Gatwick Northern Runway Project DCO (Project Reference: TR020005)

Deadline 3 Submission (19 April 2024)

Joint Surrey Councils – Surrey County Council (Ref. 20044665), Mole Valley Borough Council (Ref: 20044578), Reigate and Banstead Borough Council (Ref. 20044474) and Tandridge District Council (Ref: 20043605)

FIGURE NO: 8.4.26

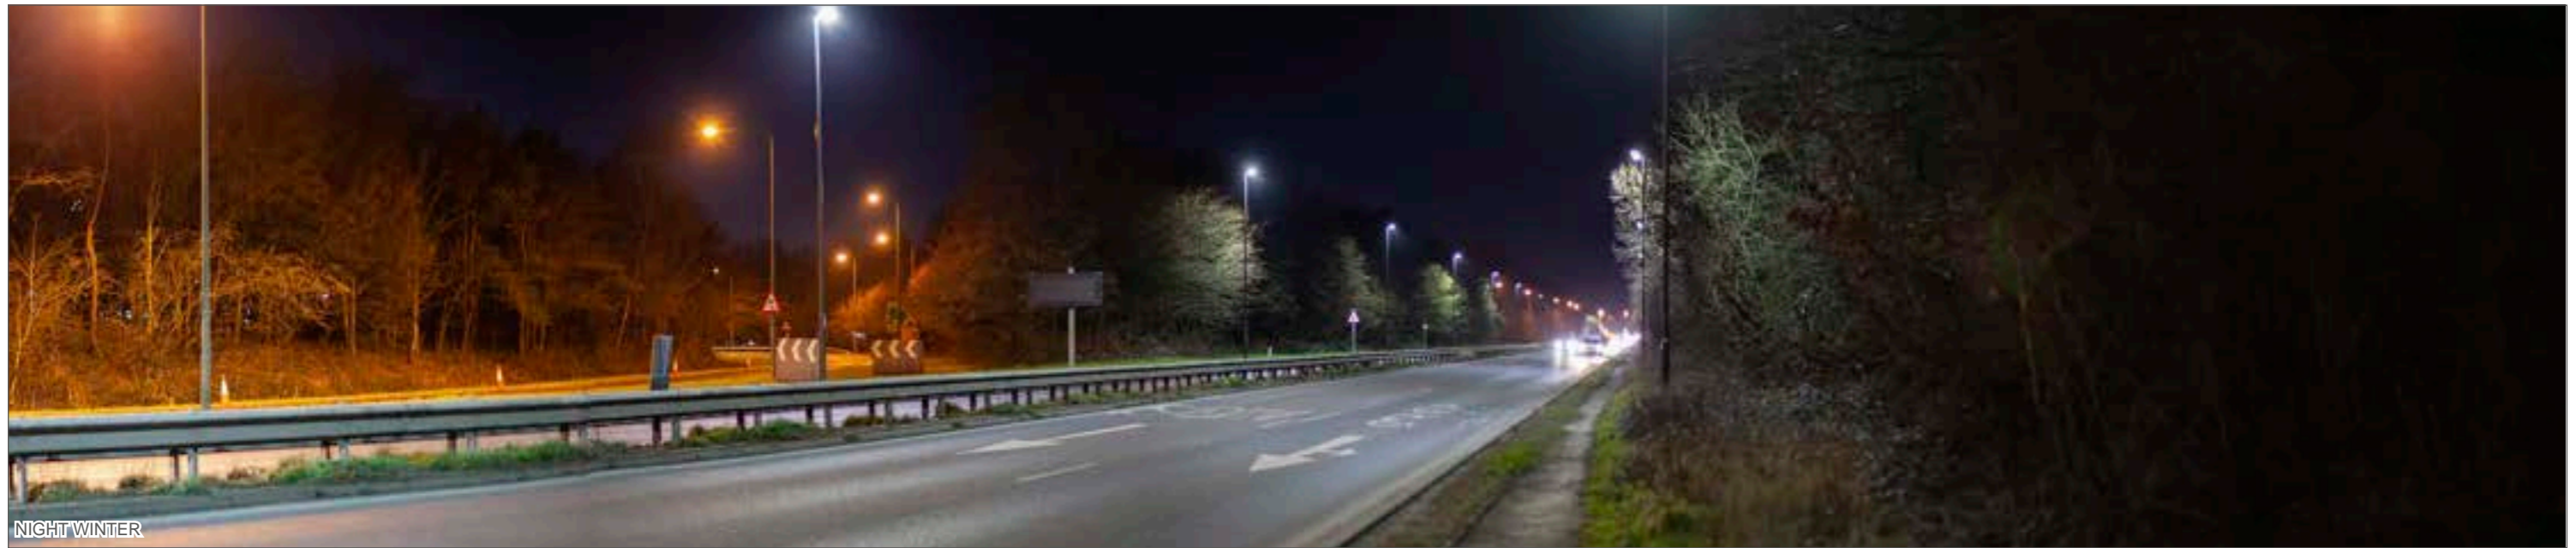
33. The Applicant has provided an update of the visual resources. With regard to Surrey imaging there do not appear to be any changes since 5.2 Environmental Statement – Landscape Townscape and Visual Resources Figures – Part 1 [APP-60]. However, at Deadline 1 the Applicant submitted document 5.3 Environmental Statement Appendix 8.10.1 – Tree Survey Report and Arboricultural Impact Assessment [REP1-206] which identified the trees for removal. It is surprising therefore that the opportunity was not taken by the Applicant at Deadline 2 to include Photoshop imaging of the tree and vegetation removal identified in REP1-026. Effectively much of the tree and vegetation cover shown along the A23 will be removed as a result of the road and bridge works. Figures 8.4.10-12 indicate that residents in

Riverside Gardens will see a significant reduction in the current green barrier along the A23. The vegetation on the A23 footpath contained in Figures 8.4.26 and 8.4.27 will be largely removed by the project.
